Please could this email EOT agreement be added to the system for LU/252/19/PL.

From: Richard Castro-Parker <Richard.Castro-Parker@arun.gov.uk>
Sent: 04 November 2019 14:05
To: Guy Storey [REDACTED]
Cc: Juan Baeza <Juan.Baeza@arun.gov.uk>
Subject: Yeomans Honda consultee comments.

Drawing
PROPOSED SITE PLAN

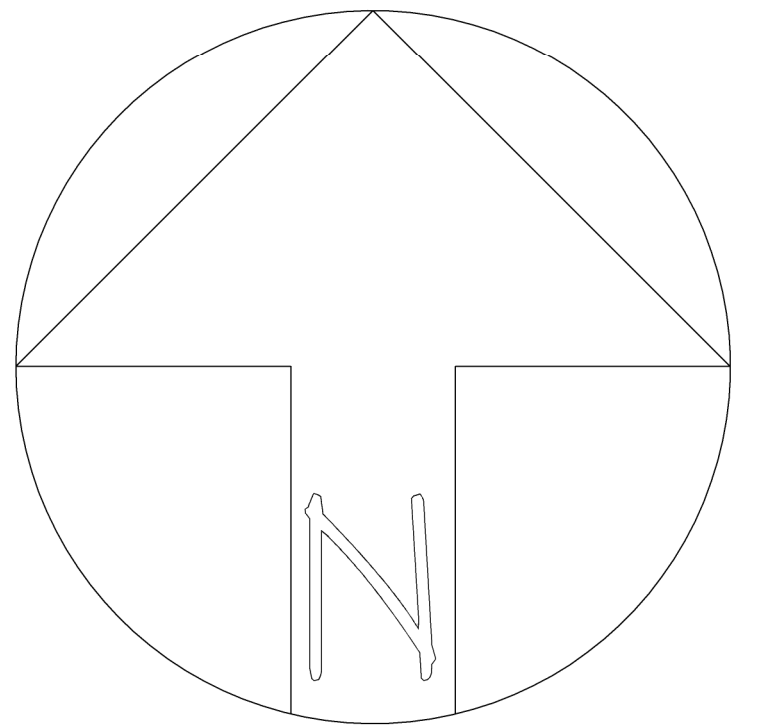
It would seem that the area was suitably remediated as part of the Permitted change from petrol filling to forecourt some years ago (the Applicant informs me that the fuel tanks were slurry/grout filled). The tanks are still in place and would be in the area now being changed in terms of levels and so it would be unwise to disturb and/or infiltrate to the ground in this area, both for the existence of the tanks and for any pollutants that may exist outside of the immediate tank area.

The flow to main sewer (mentioned in my previous message) would seem to have been a requirement of the previous conversion, where the car washing effluent was required to go to the sewer with a commercial licence from Southern Water. There is no change in impermeable area (and therefore volume) being discharged to the sewer.

Therefore, if it can be shown that all of the above is correct with the new channel drains being connected via the same arrangements as previously and Southern Water have no concern regarding the revised arrangement, I have no objection to the proposals. It would be worthwhile ensuring a management plan was in place to ensure that the channel drains were cleaned out on a sufficient frequency so as to avoid the risk of direct discharge to the highway.

In principle, the Local Highway Authority (LHA) has no concerns with the proposed works, however the applicants needs to ensure that none of the works will be within the extent of public highway. There seems to be some inconsistencies between the existing features on the proposed plan and what is present on the ground. The block plan demonstrates the existing slot drain at southern access aligns with the existing dwarf wall. This does not seem to be the case on the ground. This makes it difficult to establish if any of the proposed works, namely at the southern access point, will take place on the public highway.

The LHA would ask this is clarified by the applicant, so that suitable informative can be provided if required.

That the area was suitably remediated as part of the Permitted change from petrol filling to forecourt. The fuel tanks were slurry/grout filled. The tanks are still in place and would be in the area now being changed in terms of levels and so it would definitely be unwise to disturb and/or infiltrate to the ground in this area, both for the existence of the tanks and for any pollutants that may exist outside of the immediate tank area. I would point out again that the ground will not be broken to ensure that any potential pollutants will not be disturbed.

The discharge to main sewer was a requirement of the previous conversion, where the car washing effluent was required to go to the sewer with a commercial trade effluent discharge licence from Southern Water.

There is no change in impermeable area (and therefore volume) being discharged to the sewer.

The new channel drains will be connected via the same arrangements as previously.

As part of the works I can confirm that the existing on site drainage will be fully cleaned to ensure that it is operating correctly & that no direct discharge to the highway will occur.

The applicant has an ongoing drainage management plan whereby the drainage system & in particular the drainage channels are cleared of any silt or vegetation on an annual basis. I think that an advisory note requiring that the Applicant must ensure that no direct discharge to the highway occurs would be acceptable as is an existing requirement of the site operation.

I can confirm that none of the works will take place on the public highway.
